Our Case Number: ABP-314724-22

Re: Railway (Metrolink - Estuary to Charlemont via Dublin Airport) Order [2022]
Metrolink. Estuary through Swords, Dublin Airport, Ballymun, Glasnevin and City Centre to
Charlemont, Co. Dublin

Estuary Court Submission No. 2

Short- and Long-Term Impact of the Proposed Metrolink Route Through Estuary court

Project	Drawing Title	Drawing Status
Estuary - Seatown Landscape Layout Preliminary Design Issue		S4
Drawing N°	ML1-JAI-ARL-SC01_XX-DR-Y-00001	
Scales Original Size A1	1:1000	Sheet 1 of 3

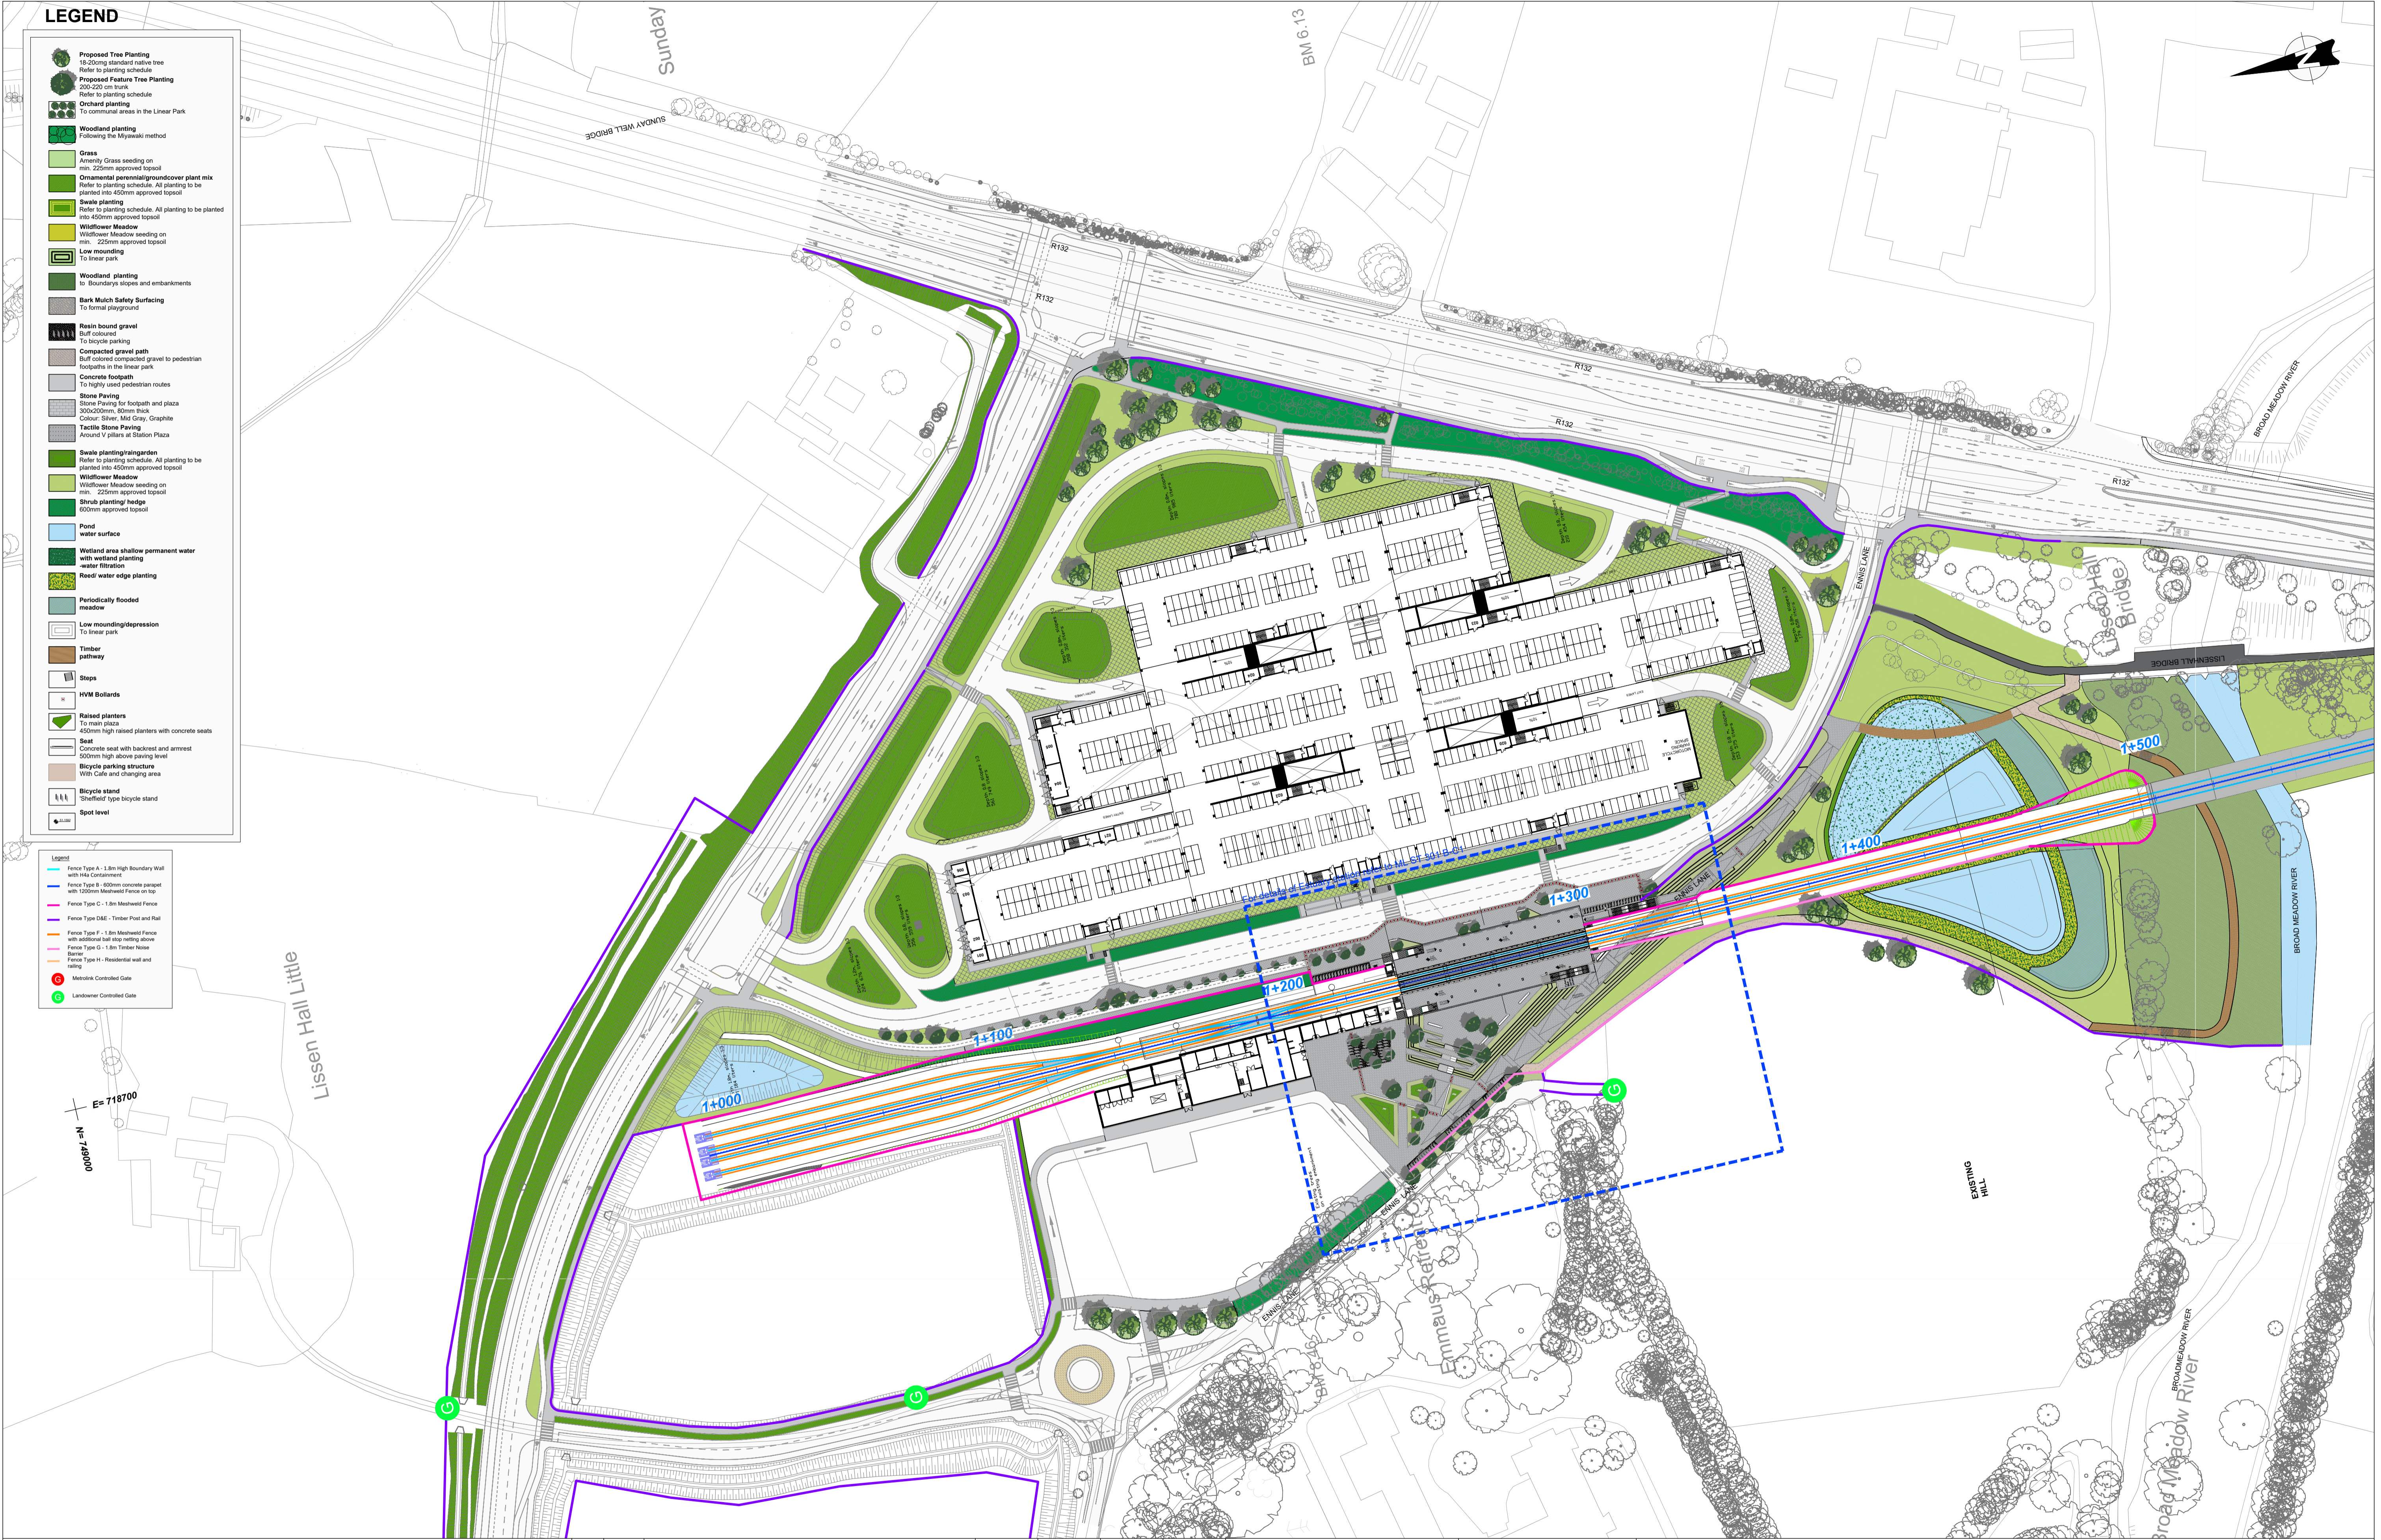
The proposed plan in the Rail Order now includes for a boundary wall (wall type H) and appears to be in a similar location to our existing wall (to be confirmed). However, the wall also includes for four access gaps in the wall (see Fig 3.2 below). This poses a security risk for both our houses and for our and the safety of our children playing on the green.

The wall is specified on the drawing as Fence Type H – Residential wall and railing however, there is no further details or height provided for this. There is a drawing for Fence Type H in the Rail Order (see Fig 3.3 below) however, this drawing is for a football goal post and ball stopping net and obviously not intended for this location.

We note there is a drawing included in the rail Order for Fence Type A (see Fig 3.4 below). This is a solid stone wall approx. 2m high and would be the closet match to what we currently have.

The existing boundary wall is a key component that makes our estate safe and secure while also acting as a noise barrier and along with the mature landscaping aesthetically enhancing our estate. A wall with access points, is not secure for children. The main reason the wall was built by the council in the first place was for the safety of children and this is still relevant today. The residents do not want any access points in it. We believe it is a reasonable request for the wall to be reinstated end to end, like for like. We note the General Arrangement drawing for this area (see Fig 3.5 below) in the Rail Order specifies for the existing wall to be replaced.
